**KIRKLEES METROPOLITAN COUNCIL  
INVESTMENT & REGENERATION SERVICE**

Reference No:	<b>2024/44/93526/W</b>
Site Address:	adj, 18B, Cowlersley Lane, Cowlersley, Huddersfield, HD4 5TY
Description:	Discharge of details reserved by conditions 3 (facing materials), 7 (floor levels), 9 (walls and fences), 10 (risk assessment), 15 (land stability), 16 (noise), 18 (renewable energy) on previous permission 2023/90582 for erection of 2 detached dwellings
Recommending Officer:	Elenya Jackson

**DECISION – Discharge of Conditions – Split Decision**

## Officer Report

Surveyed by JA	Drawn by JA	Approved by
Drawing No. 0724-ROG-11076	Date 18-07-2024	Revision
Scale 1:200@ A1		Sheet No. 1 of 1

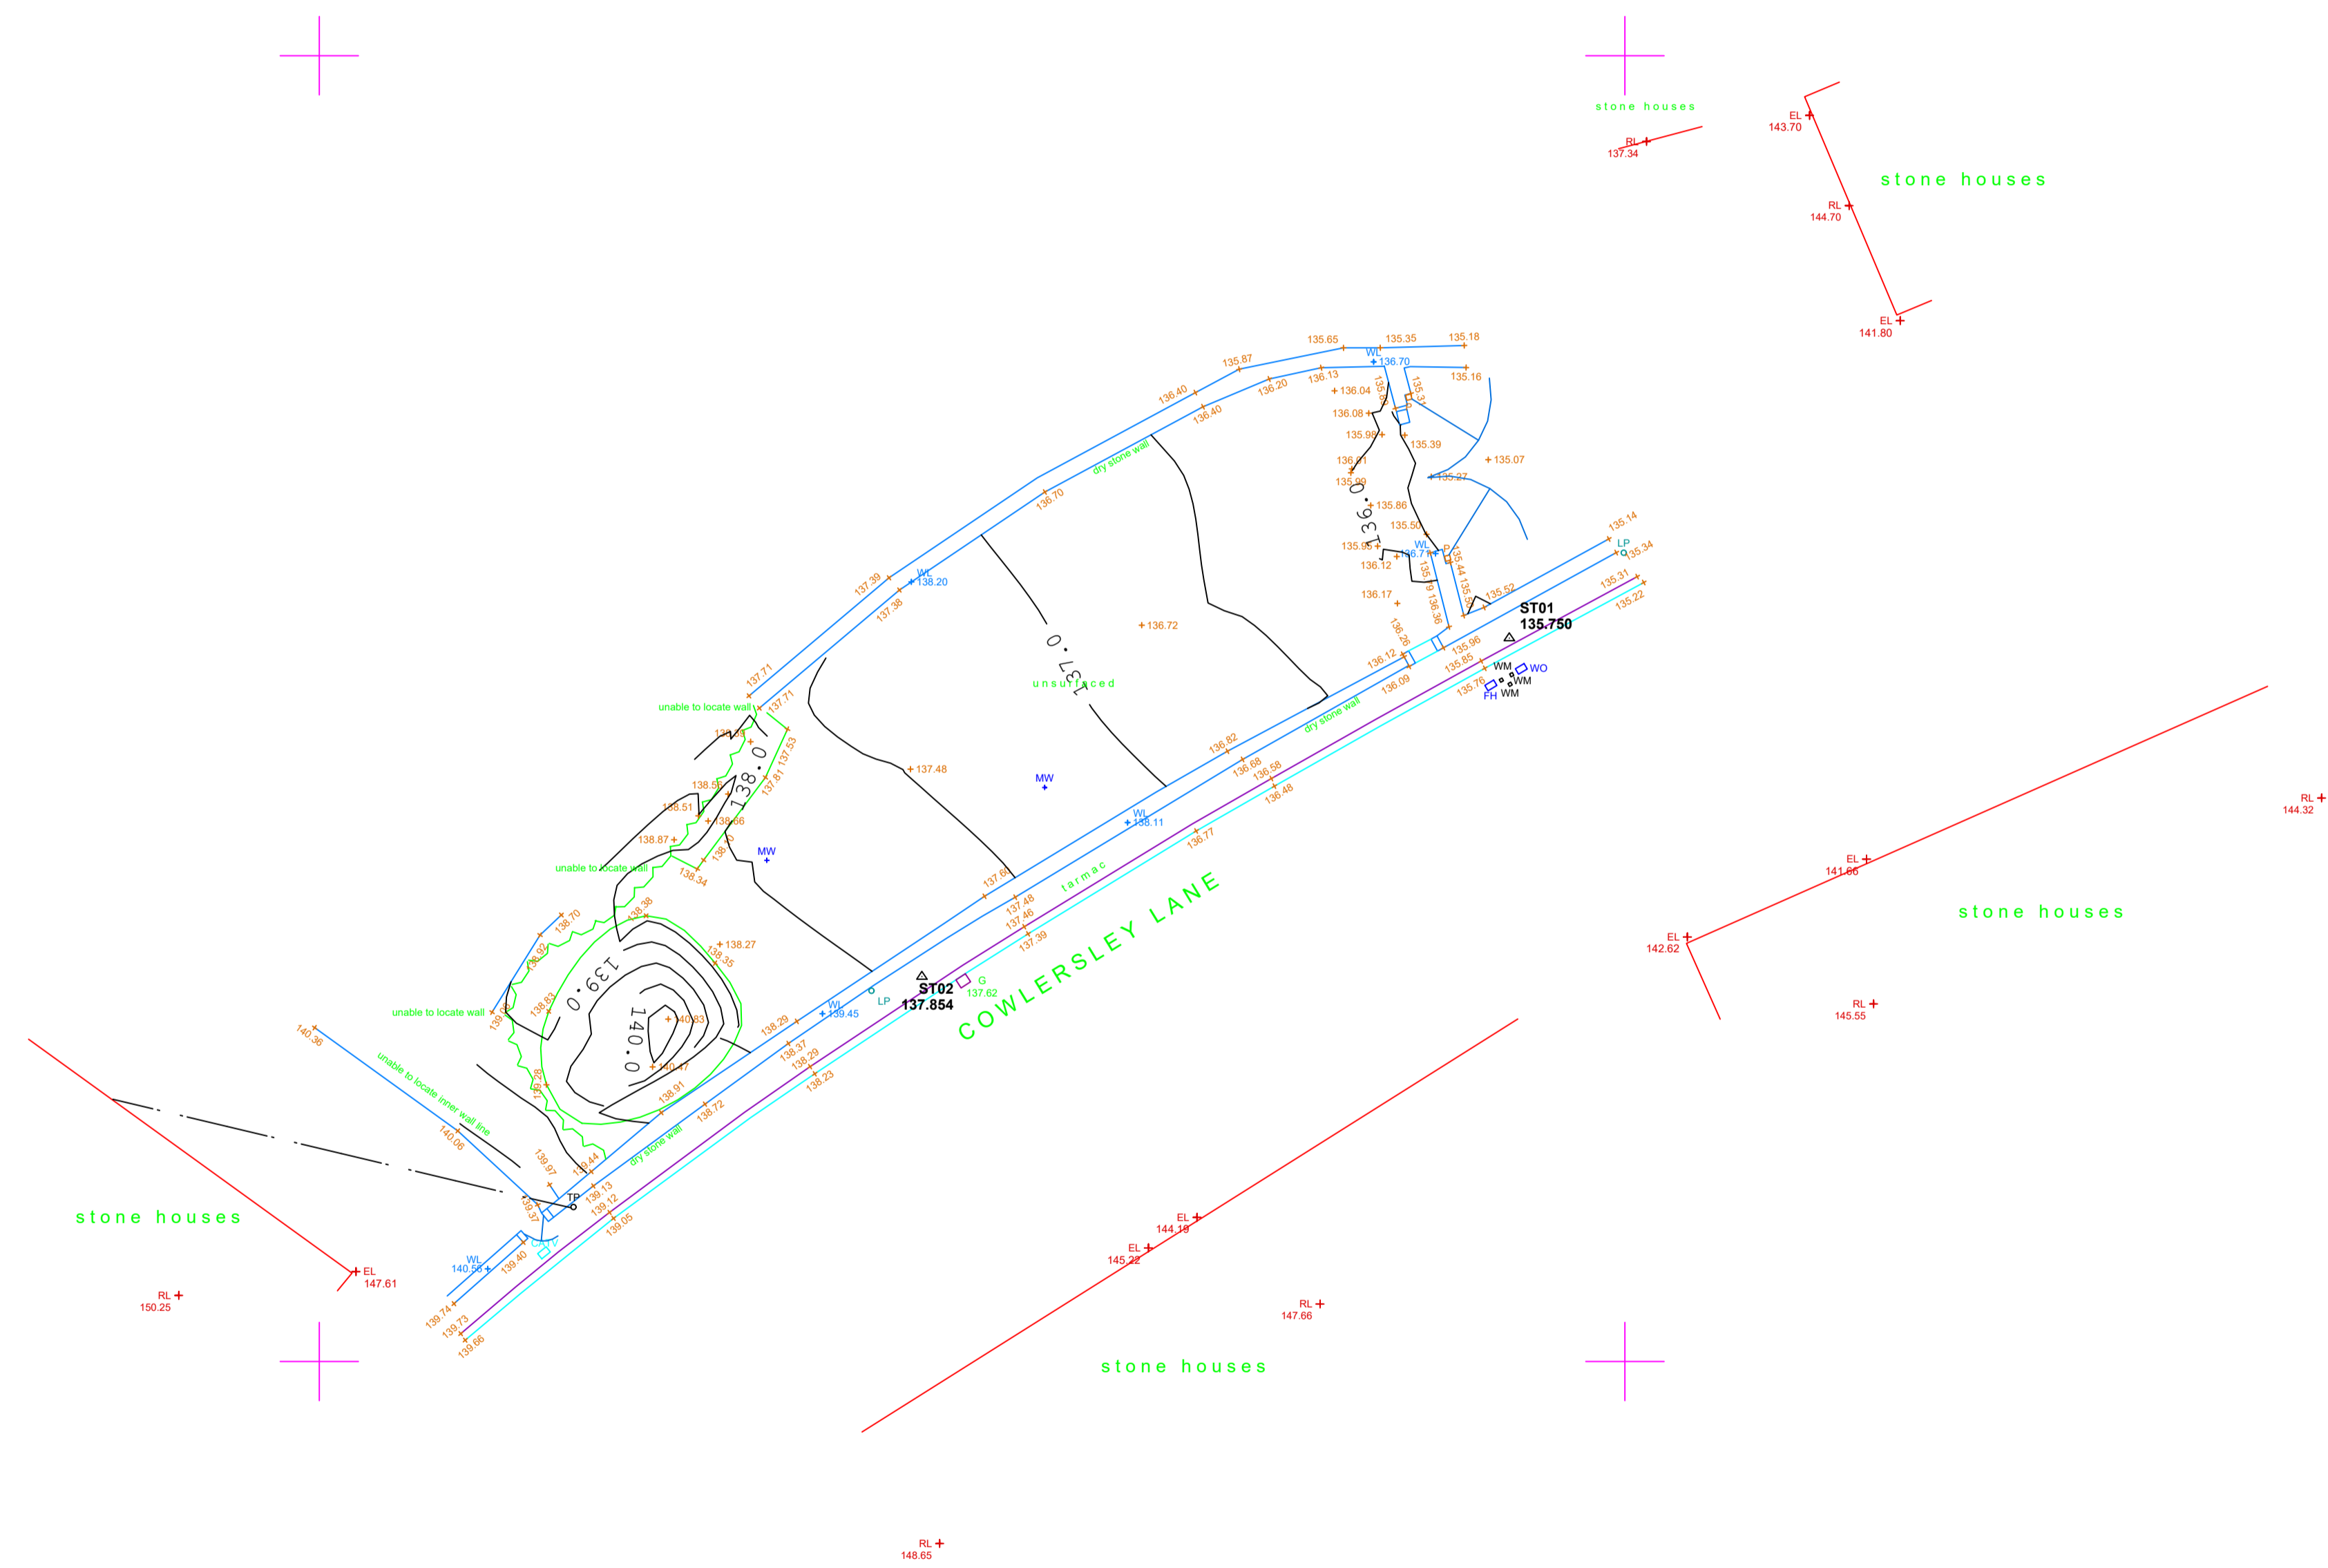
- Sheet 1 of 1 site levels

The plans provided indicate that the site would increase in topography from north to west and would be marginally higher than Cowersley lane.

Within the officer report for the previous permission, it was commented that existing and proposed site/floor levels should be provided to ensure the proposal would accord with LP24 of the Kirklees Local Plan and for the avoidance of doubt, so that it will be clear how proposed levels relate to the existing topography.

It is considered that, the plans show the existing site levels but not the proposed with the dwellings in situ; therefore, the plan does not satisfy the full requirement of condition 7 and it cannot be discharged.

It is considered that, the plans show the existing site levels but not the proposed with the dwellings in situ; therefore, the plan do not satisfy the full requirement of condition 7 and it cannot be discharged.
